DECISION DELEGATED TO HEAD OF PLANNING

Application No: H23-1092-24 **Applicant:** M Kirk
Proposal: Proposed wall with wrought iron railings and gate
Location: Pipwell Manor Washway Road Saracens Head
Terminal Date: 7th April 2025

SITE LOCATION PLAN 1:1250

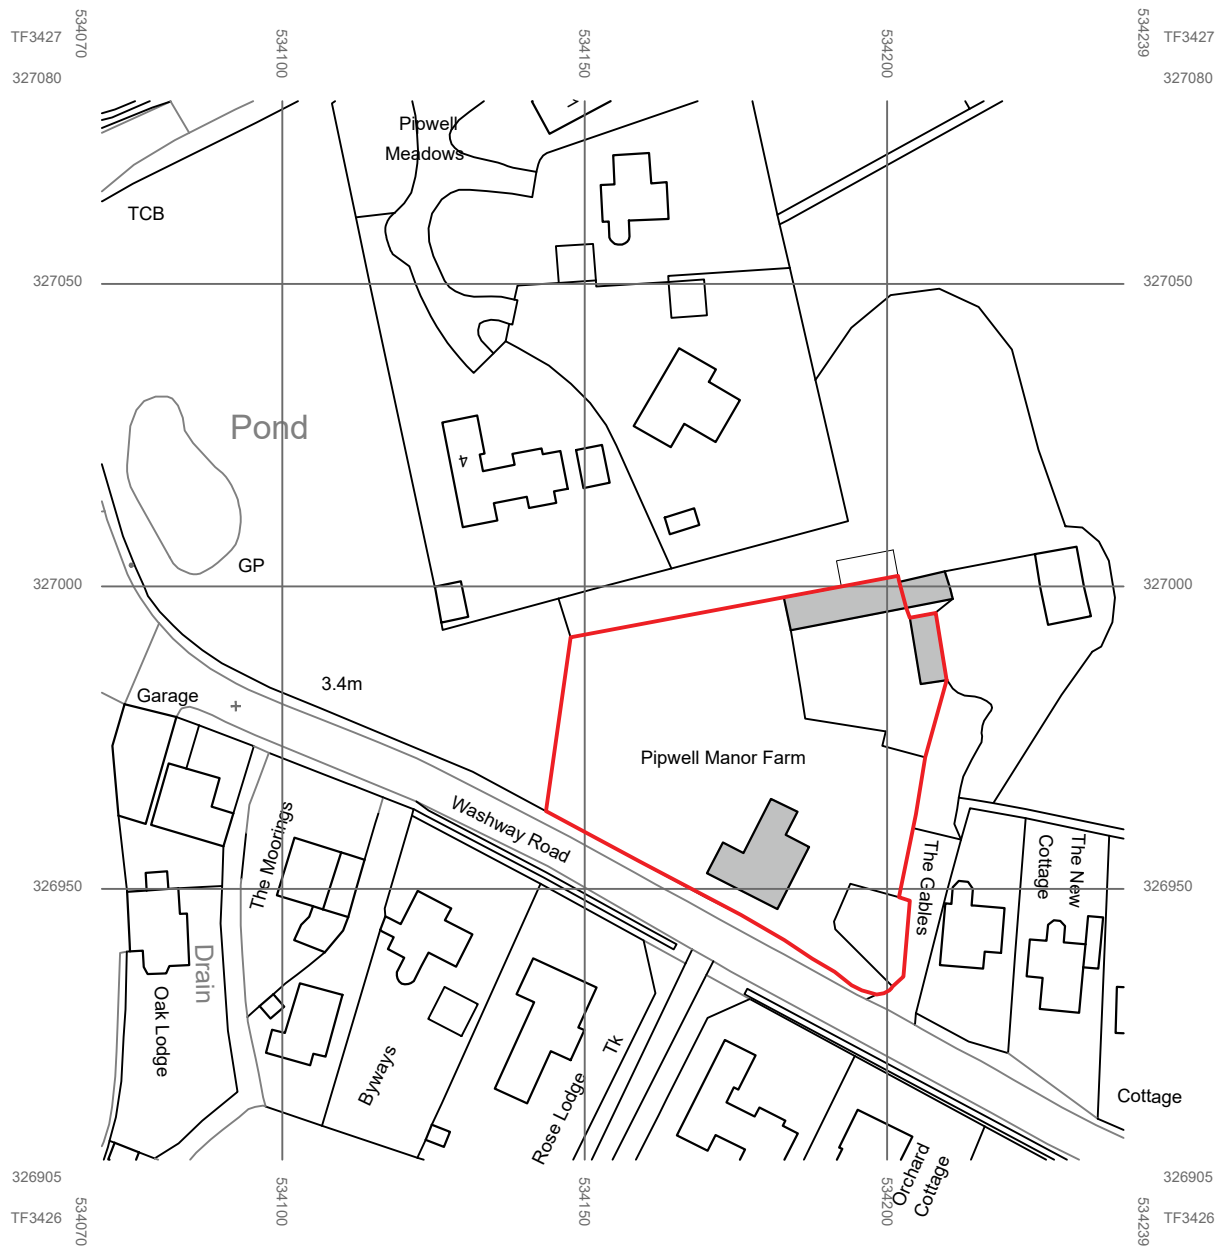
Visibility should be provided in accordance with Manual for Streets and a note should be added to the proposed site plan to state the access will be constructed to Lincolnshire County Council Specification.

In response, the agent submitted a revised site plan providing the information requested by the highway authority and demonstrating that the required visibility of 43metres in both directions can be achieved from the proposed access. Adequate parking and turning facilities exist within the site.

Drawing Stage	PLANNING
Drawing title	PROPOSED DRIVEWAY & STREET FACING BOUNDARY ALTERATIONS
Project	PIPWELL MANOR
Drawing number	0255.20 A

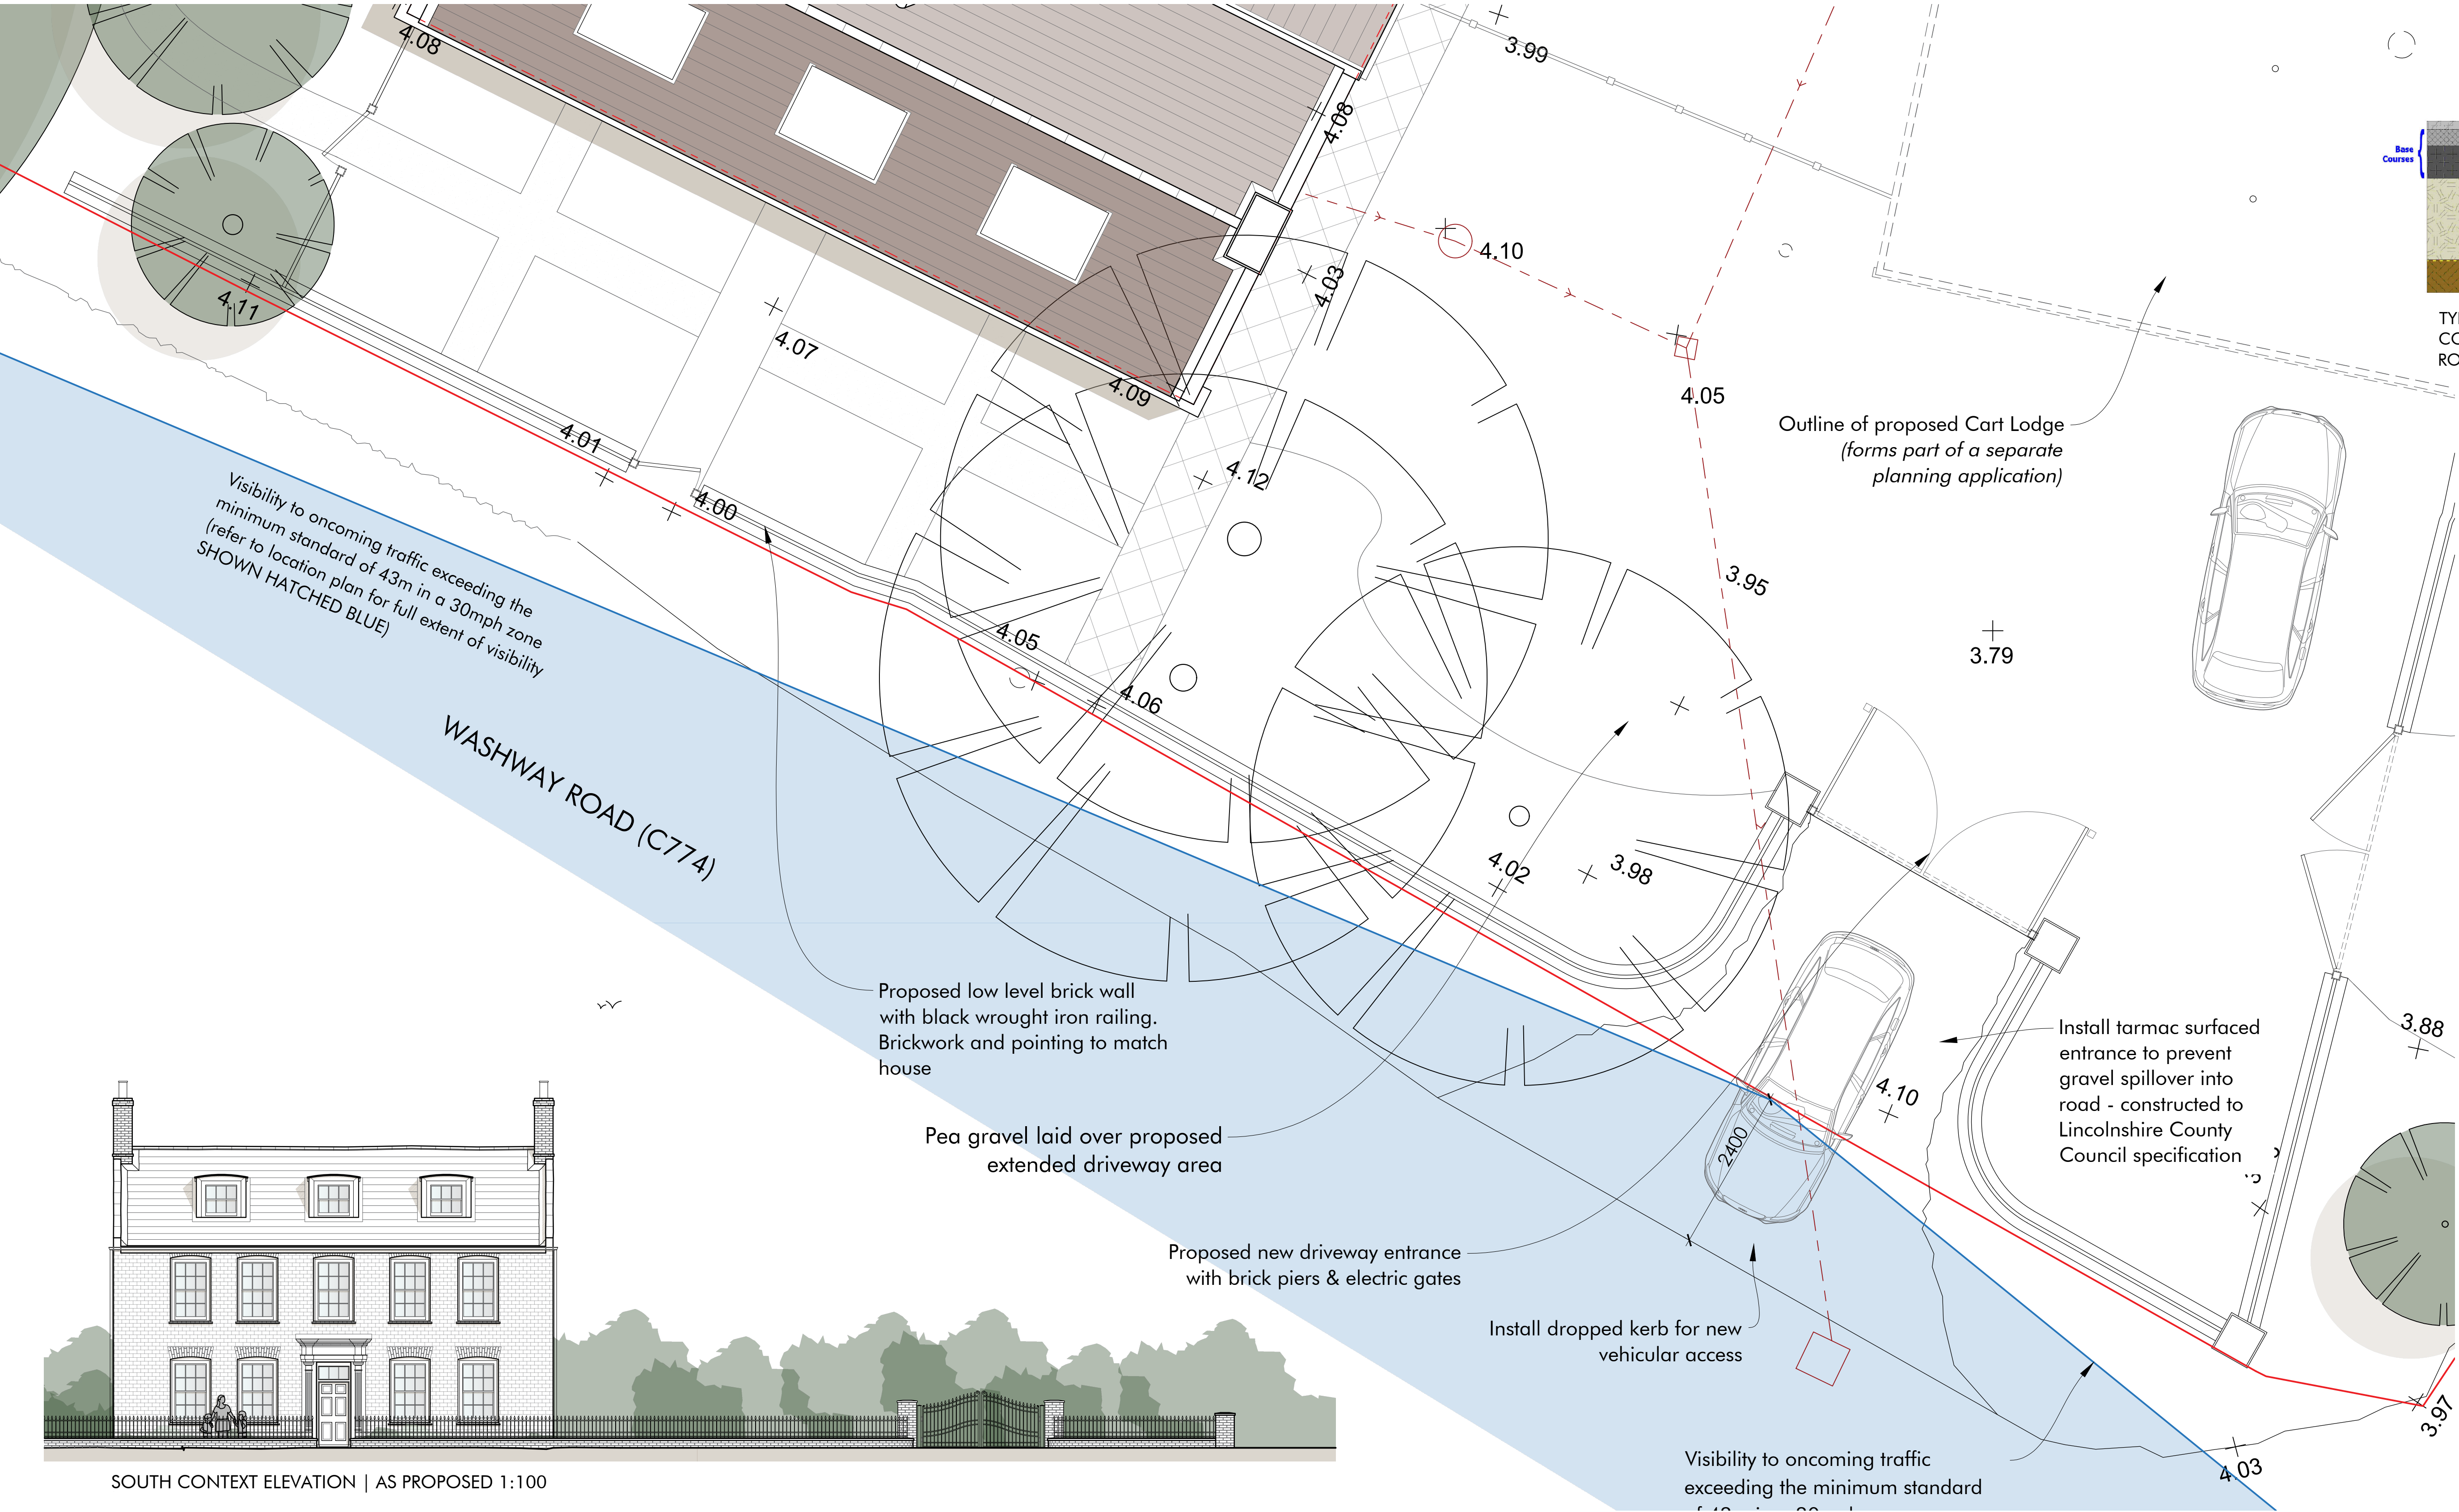
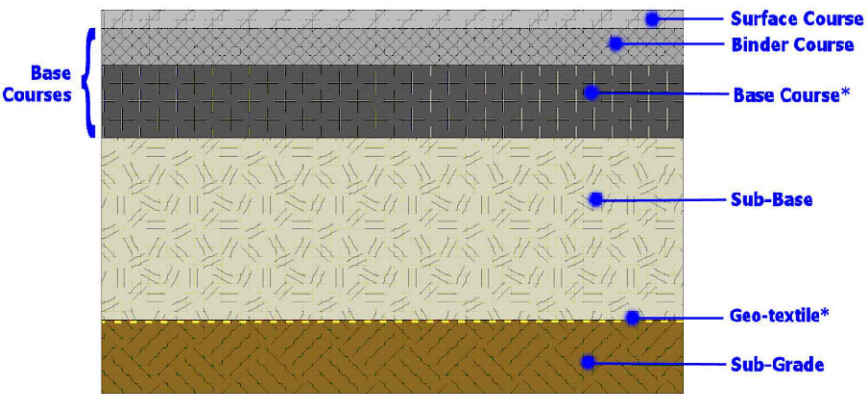
The proposal should include access construction, this is the C774 and this needs to form part of the

The highway authority initially requested further information. It was advised the proposal should include access construction, stating the C774 should form part of the planning application. In addition, the highway authority advised it should be demonstrated that visibility can be achieved in accordance with Manual for Streets and a note should be added to the proposed site plan to confirm the access will be constructed to Lincolnshire County Council Specification.

The highway authority were re-consulted and advised the amended plans were acceptable and there were no objections to the proposal on highway grounds subject to a recommended condition.
